Re: Planning application 2025/62/93355/E

Erection of 75 residential dwellings with associated landscaping, open space, highways and drainage infrastructure at Land off Woodward Court, Mirfield, WF14 OPY – FURTHER RECONSULTATION

The Coal Authority response: MATERIAL CONSIDERATION

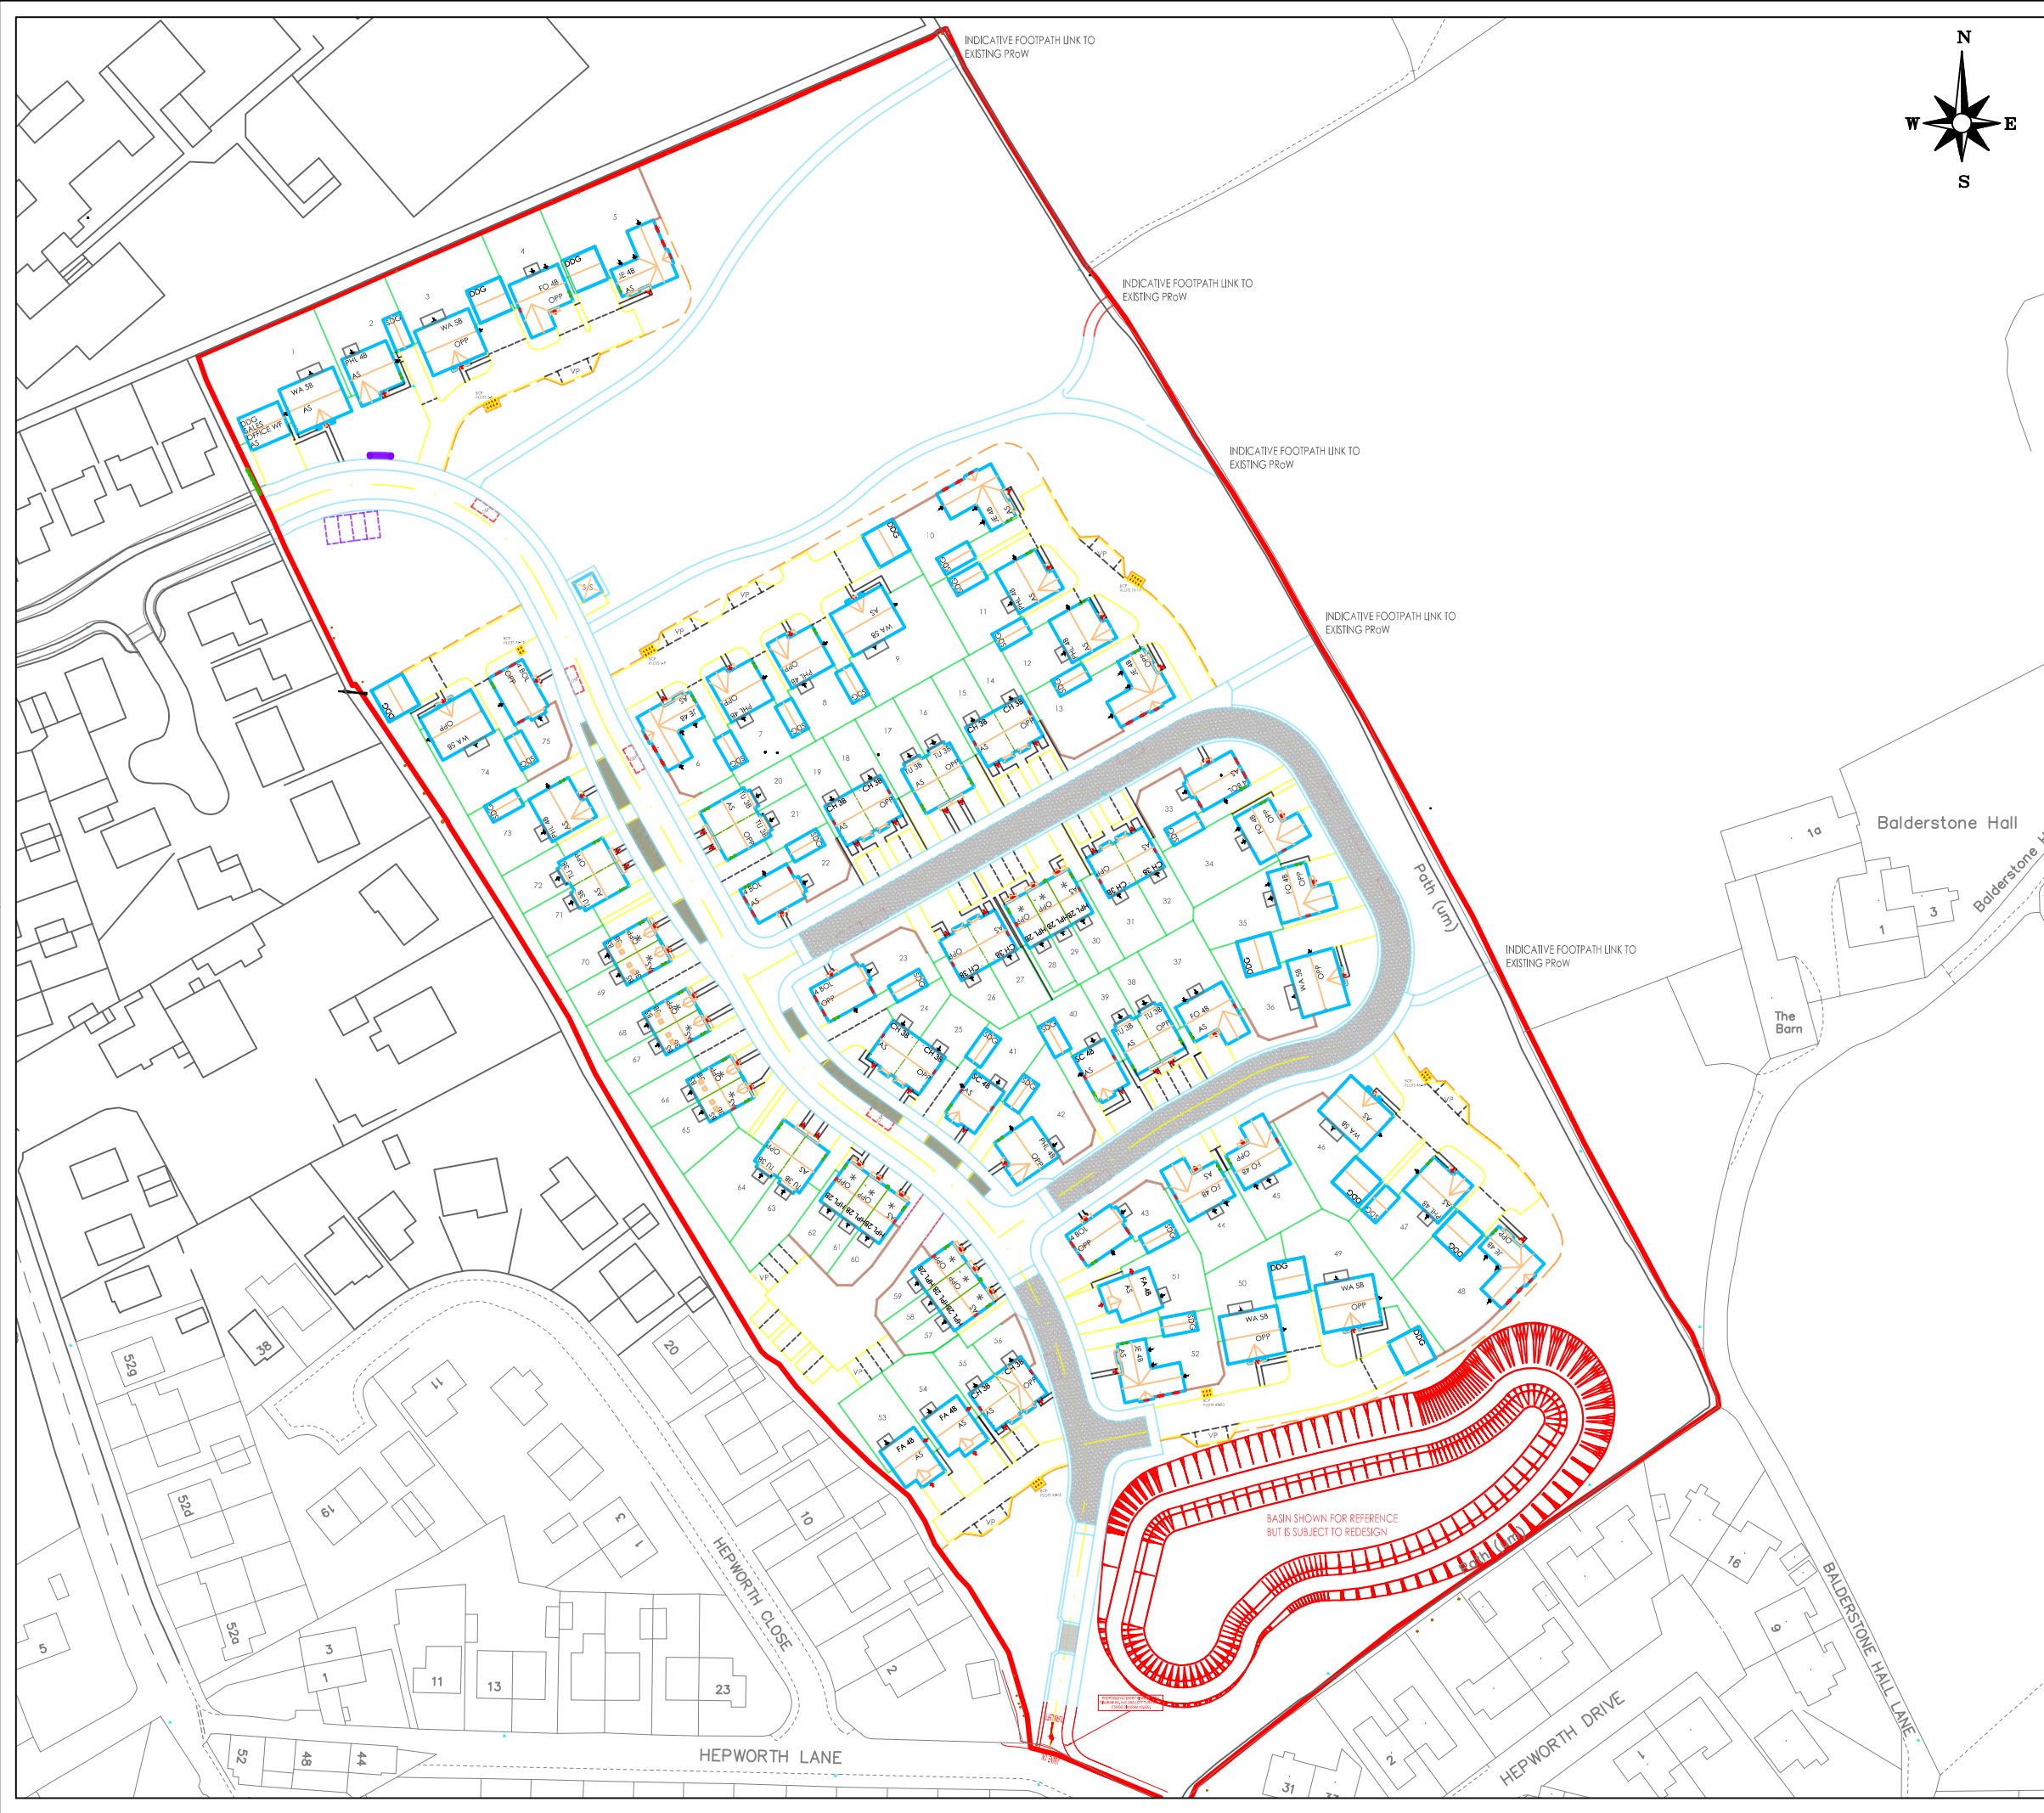
The report advises that further mine entries were encountered during the additional works, with the total rising to 15 mine entries and two likely quarry features. These are considered likely to represent bell pits or shallow shafts targeting the Blocking Coal. The positions of these features and calculated no-build zones are shown on Drawing 5670/21 Rev.A included in Appendix A. This drawing demonstrates that built development avoids

the additional features, although three of the mine entries are present at the edge of the SuDS basin. The report goes on to advise that the mine entries will require treatment, which could take the form of grouting of the backfill or capping, which would ultimately be subject to Mining Remediation Authority approval.

As with the previous version of the report, it advises that proof drilling and grouting of shallow mine workings should be carried out at those plots which are within 12m of a mine entry or the potential quarries, as shown on Drawing 5670/21 Rev.A.

'With regards to the treatment of shallow mine workings, we note that the specification document indicates that proof drilling and grouting of shallow mine workings is proposed at those plots located close to the previously identified mine entries, as shown on Drawing no. 5670/21. We note that these treatment works do not extend radially away from the mine entries but will focus on the buildings close by. The specification document indicates that the same approach will be adopted for any further mine entry features encountered elsewhere on the site.'

'Given the limited treatment works, it would appear that external parts of the site, such as roads, hard surfaced parking areas, paths and gardens near to the mine entries and presumably considered to be potentially underlain by shallow mine workings will not be treated. The justification for this approach is unclear. It is also unclear why the potential for the presence of underground workings extending further from the mine entries, and therefore potentially requiring treatment, has been discounted.'

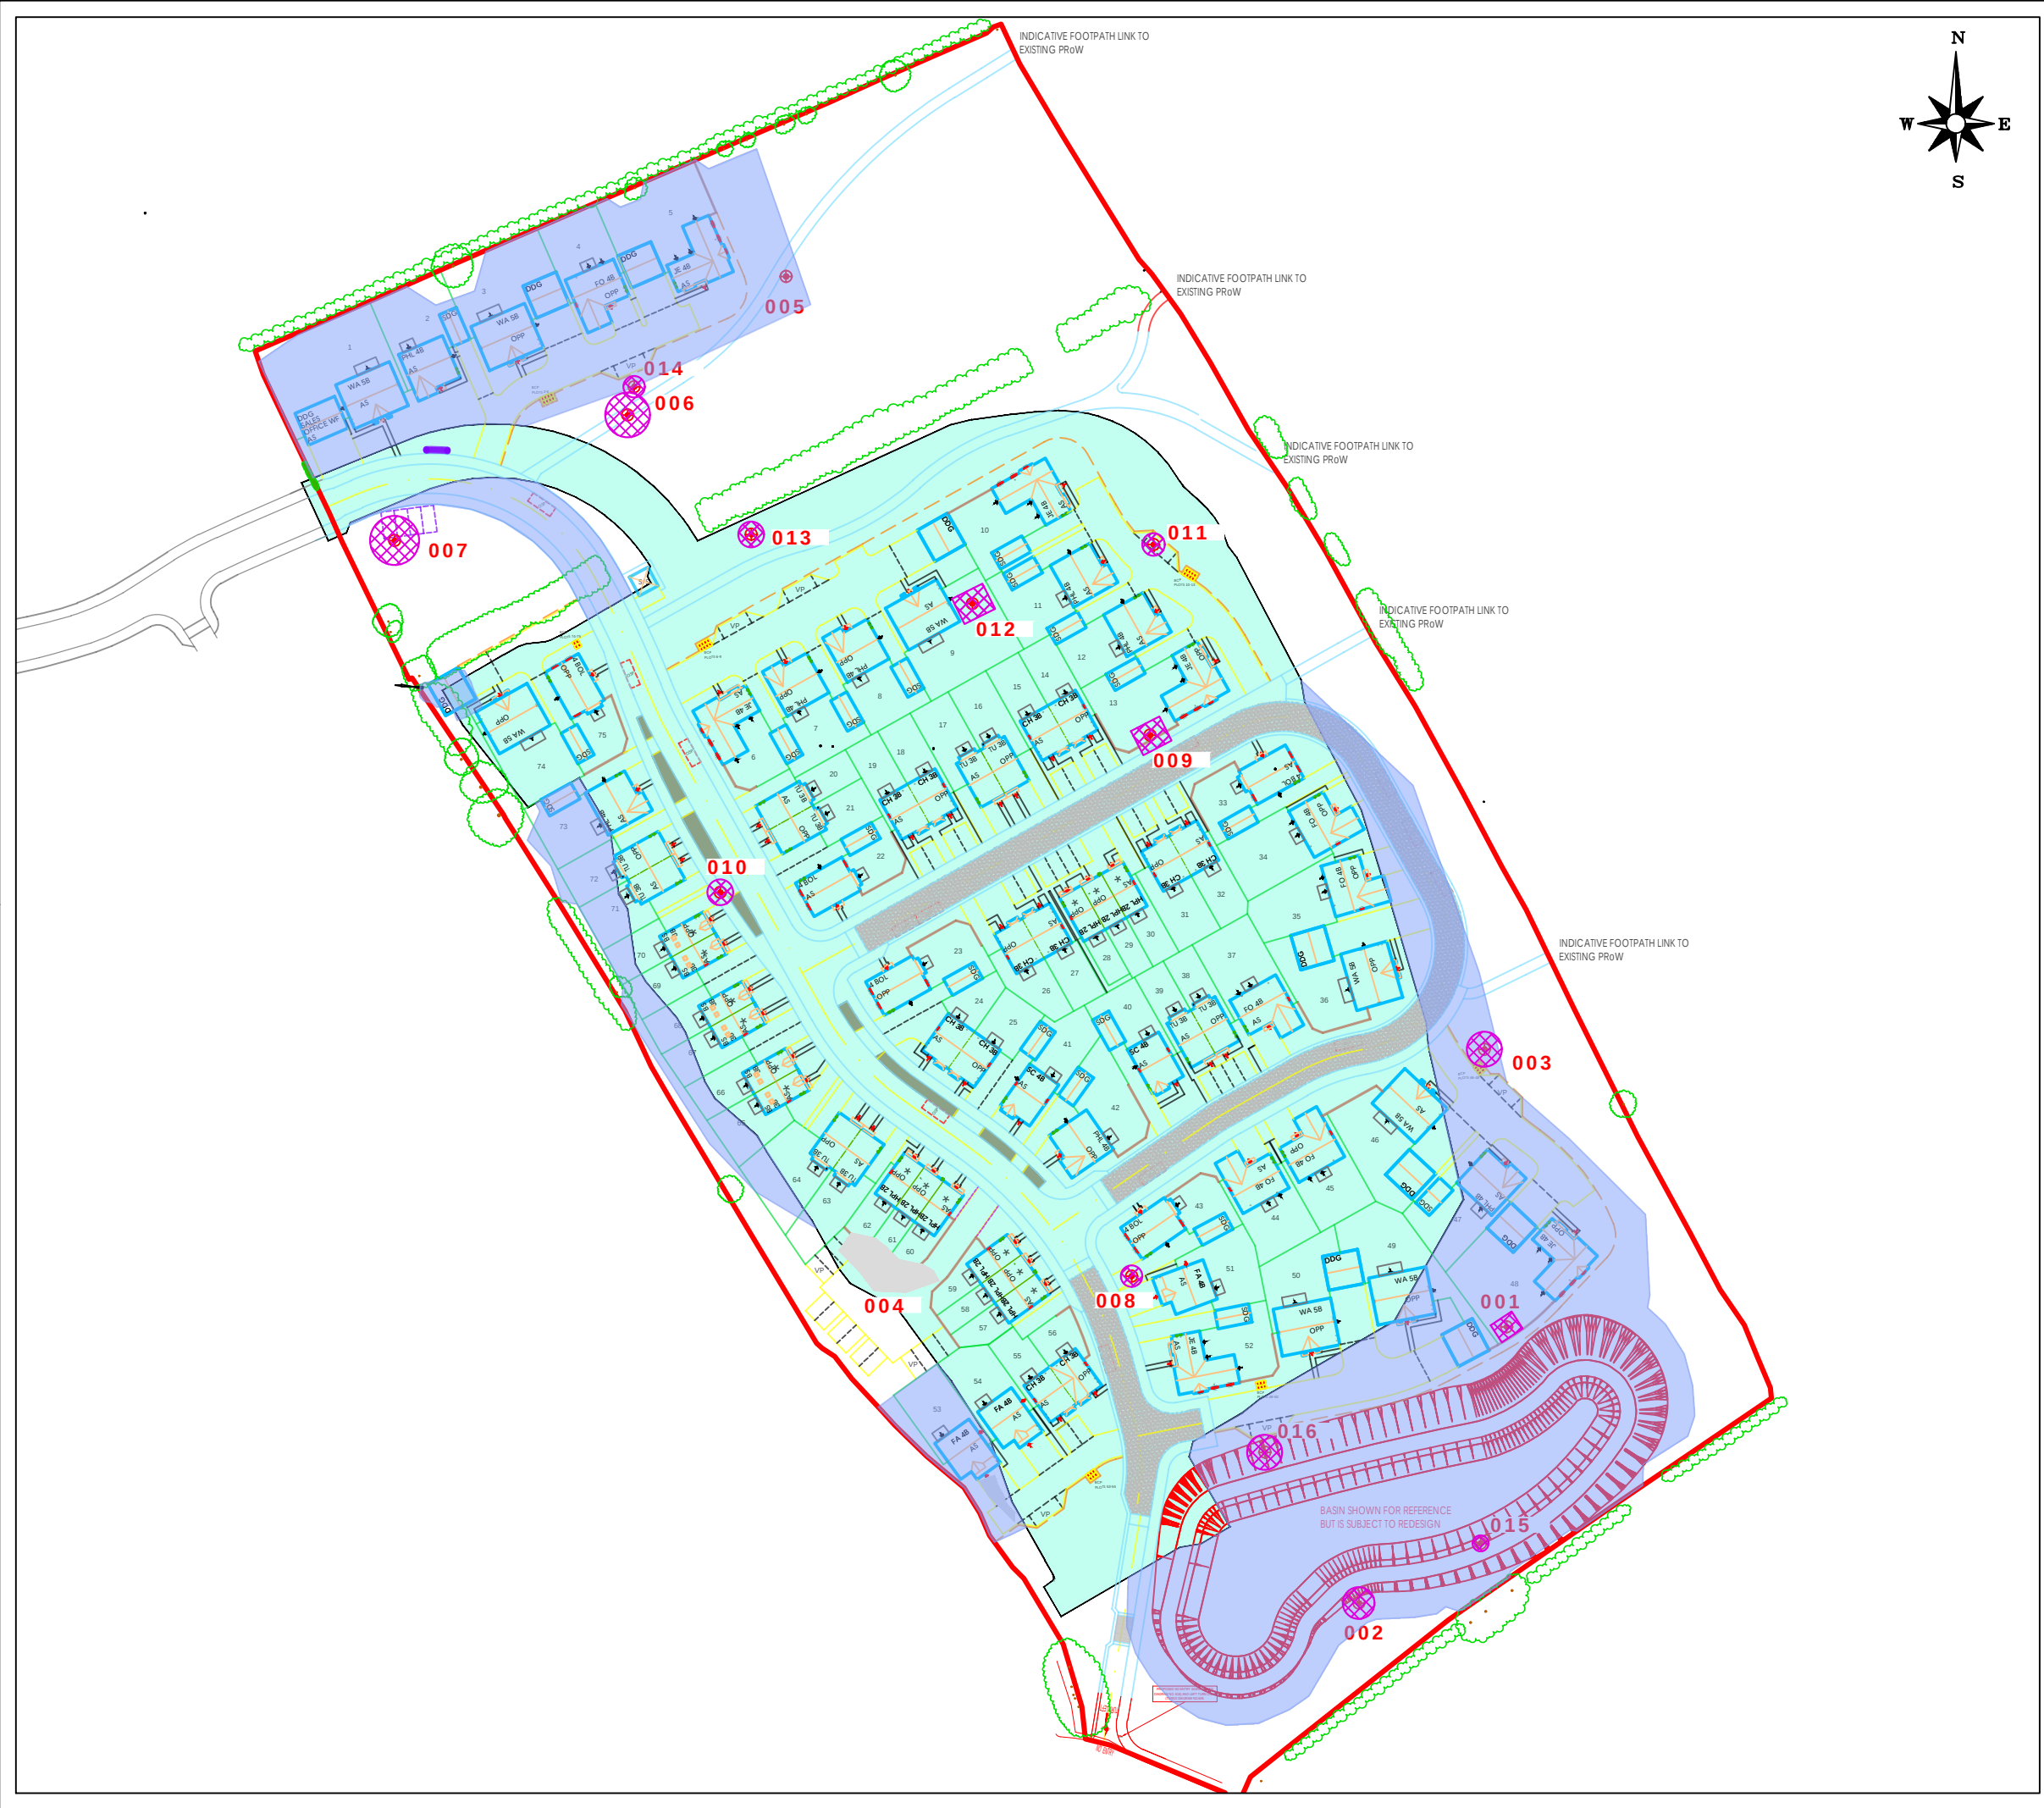
Further to matters raised in our previous consultation response letter of 26 March 2026, we note that the applicant has submitted a revised 'Specification for the investigation and treatment of shallow workings & mine entries' document (Report no. 5670/B, March 2026, prepared by Lithos Consulting) in support of their application. We are pleased to note that this report indicates that a further soil strip was undertaken in April and May 2026 across the areas of additional proposed development including the SuDS basin, as shown on Drawing 5670/22 Rev.B included in Appendix A.
